**A1 IN NORTHUMBERLAND: MORPETH TO ELLINGHAM WRITTEN REPRESENTATIONS FOR DEADLINE 2 AND 3**

**A1 IN Northumberland: Morpeth to Ellingham DCO Application Planning  
Inspectorate Reference: TR010059**

**Summary of Written Representations  
On behalf of the Environment Agency (EA)**

© Crown Copyright and Database Rights 2020 Ordnance Survey 100030649

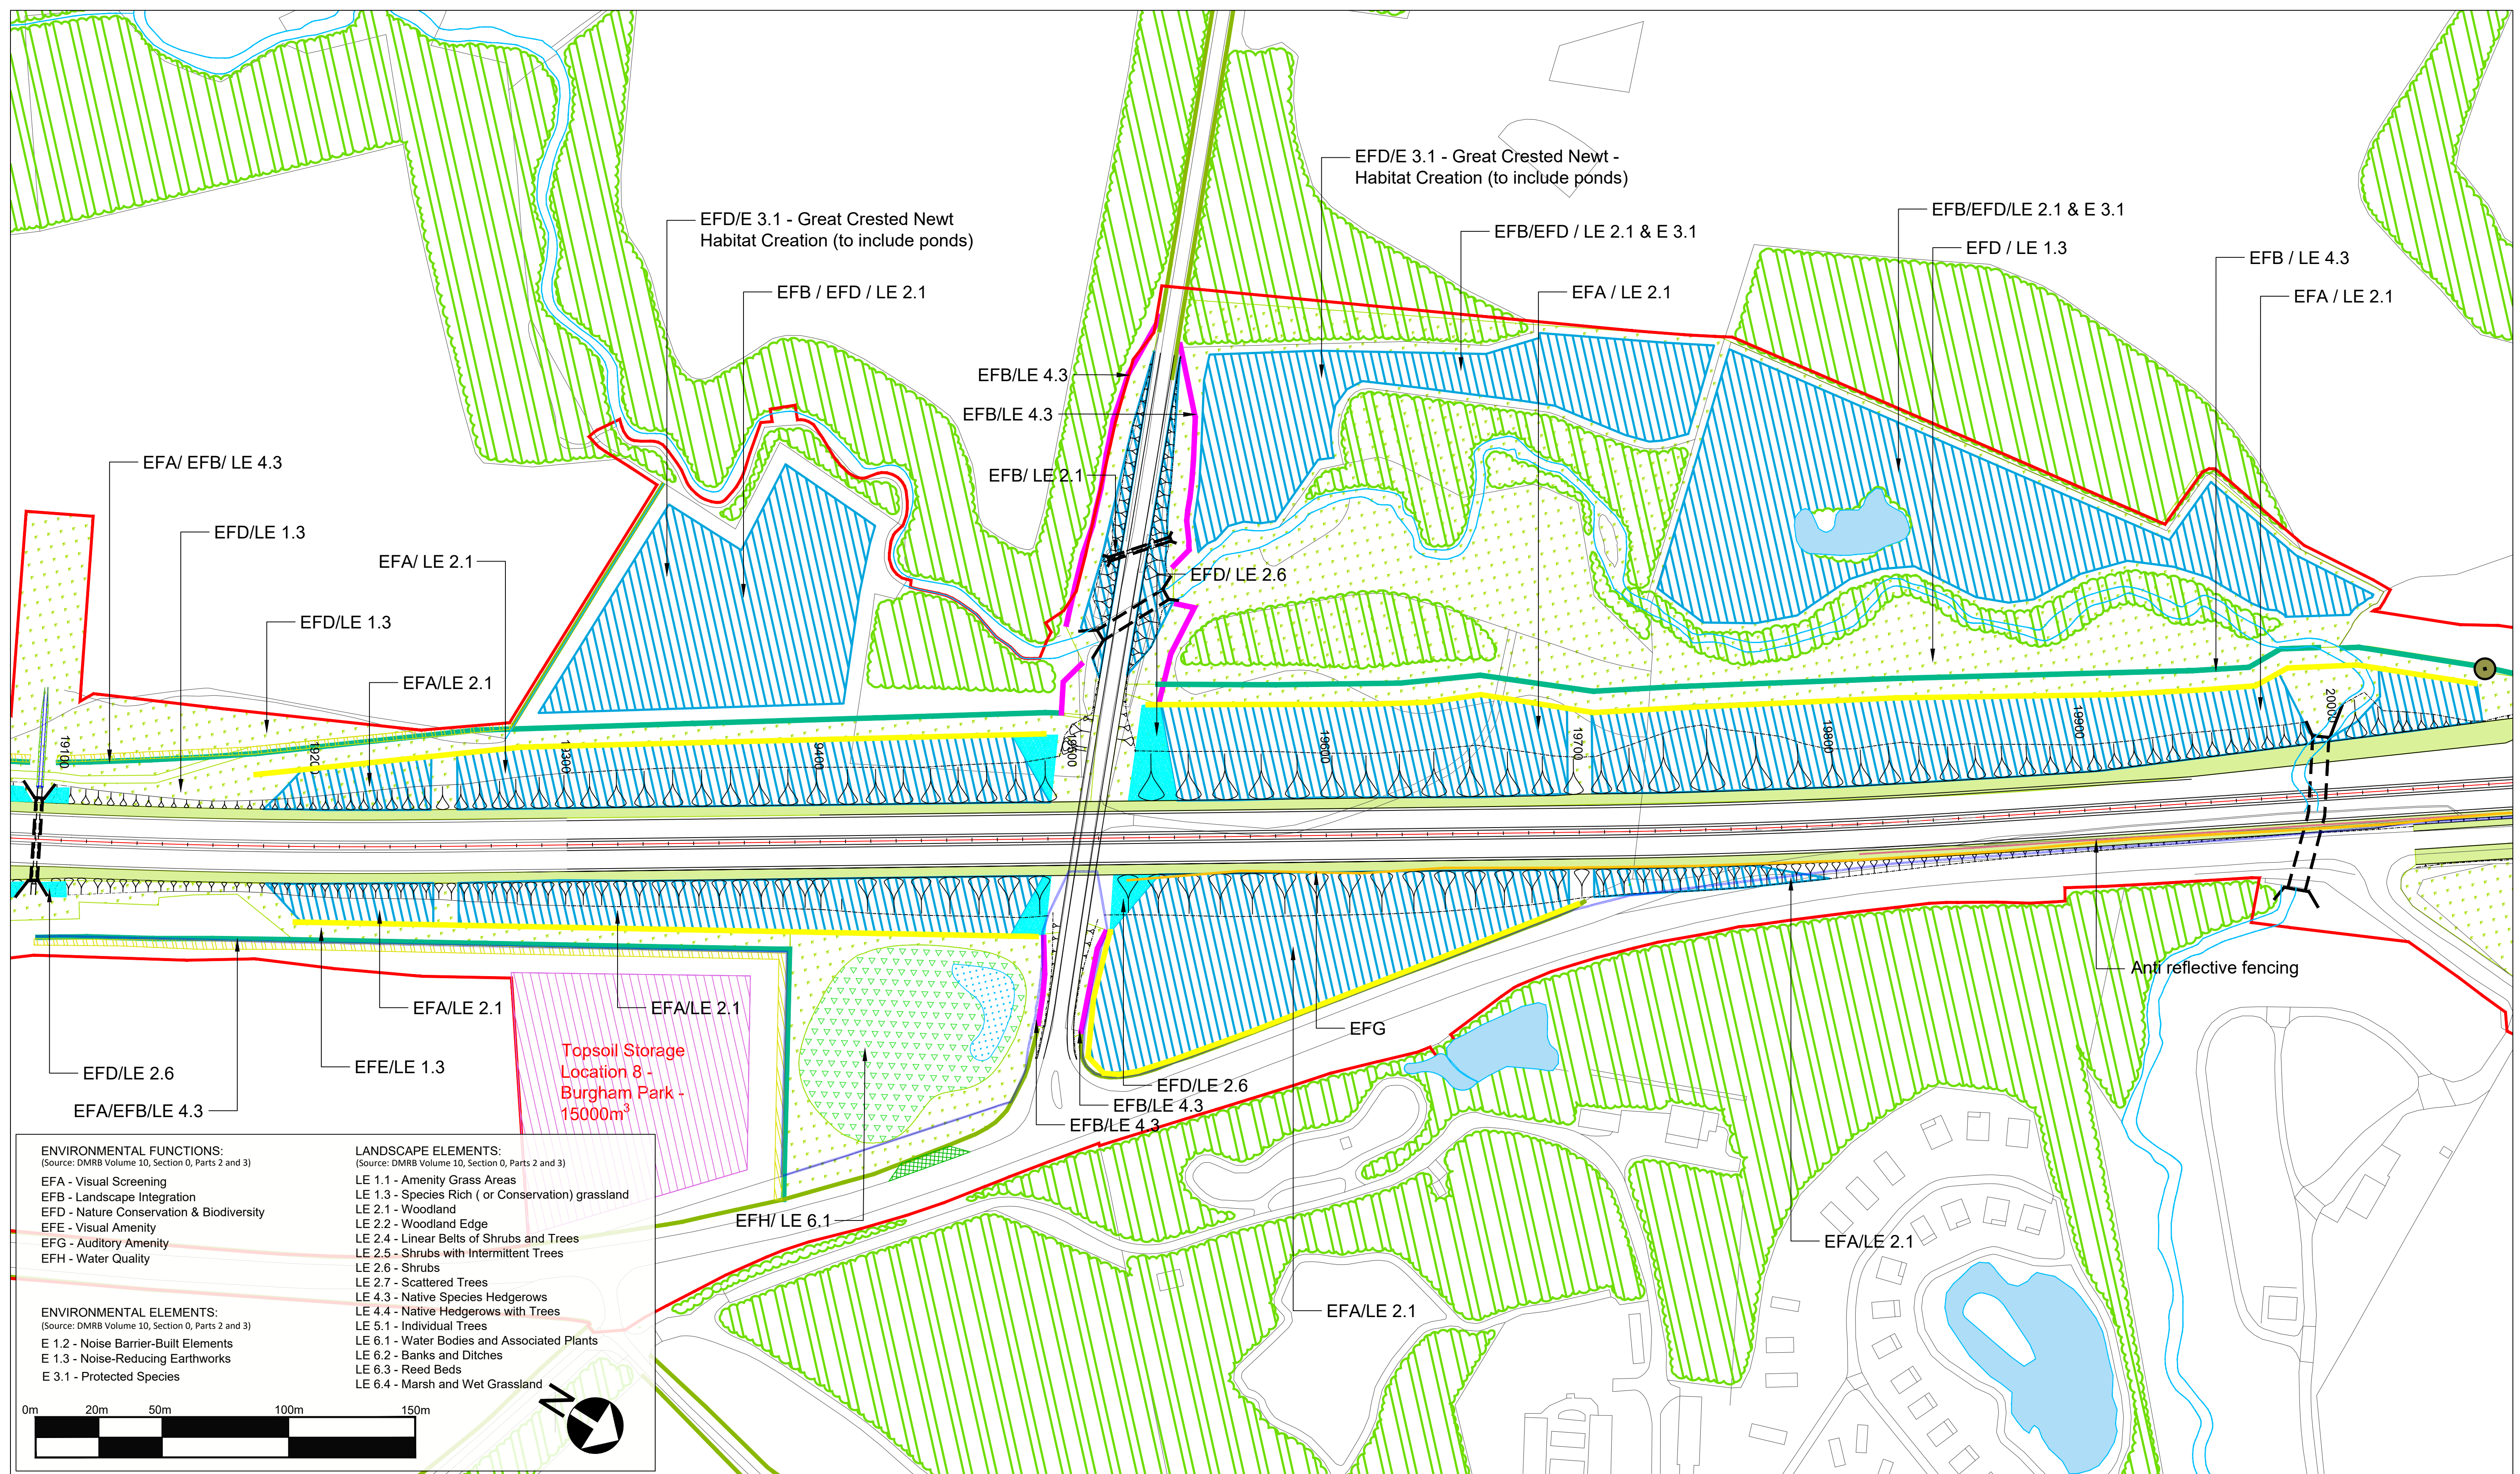
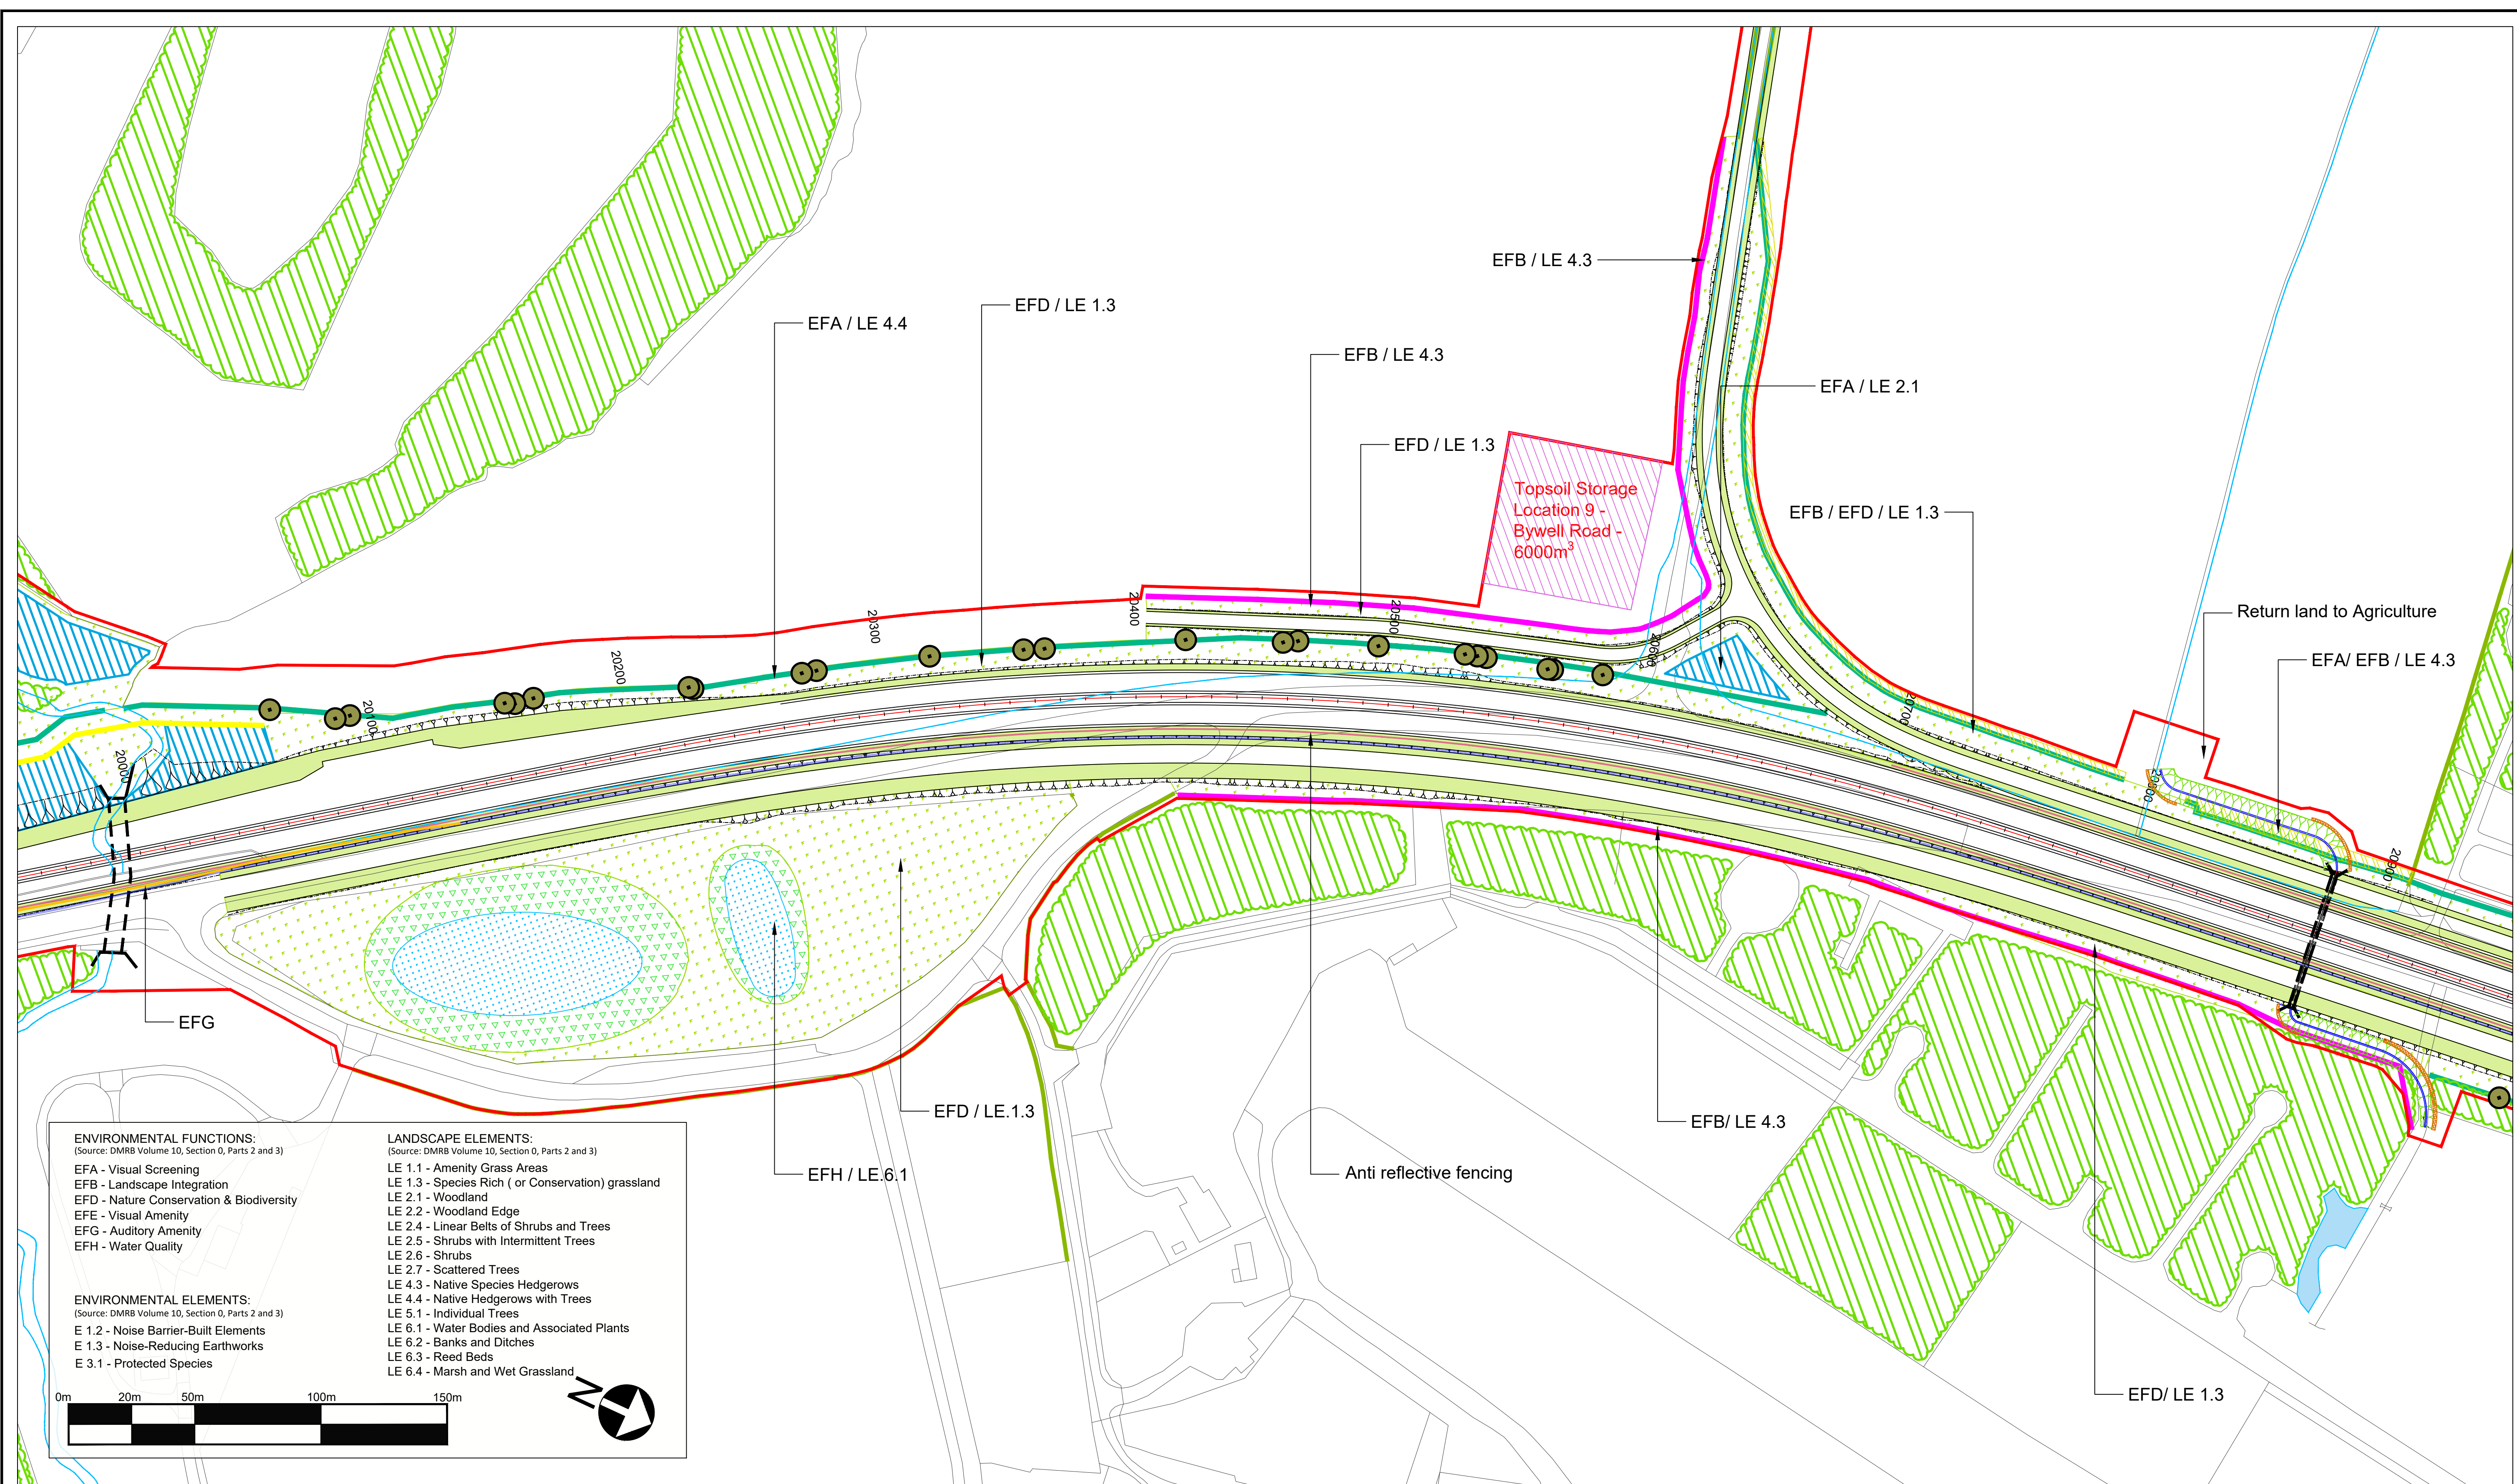
The applicant needs to provide compensation for the loss of watercourses and habitats, which is not evident in the culvert mitigation strategy or the Outline Construction Environmental Management Plan (CEMP) - Rev 2 [REP3-013]. The mitigation strategy states large areas of wet woodland will be created which we believe is an incorrect definition of the habitat created and should be reclassified as riparian woodland, unless it can be clearly demonstrated that wet woodland is being created. We are unable to see the evidence of this and would recommend that these proposals are included in the Landscape Mitigation Masterplan or similar plan.

The mitigation strategy states large areas of wet woodland will be created. We believe this is an incorrect definition of the habitat created and should be reclassified as riparian woodland, unless it can be clearly demonstrated that wet woodland is being created. The areas of 'wet woodland' created appear to align with the comments made in 7.9.1 Appendix A Response to RR-04 Environment Agency [REP1-065] which claim 'c.38ha of wet woodland and c.12ha of wetland marginal planting'. However, we are unable to see the evidence of this and request that these proposals are included in the Landscape Mitigation Masterplan or similar plan.
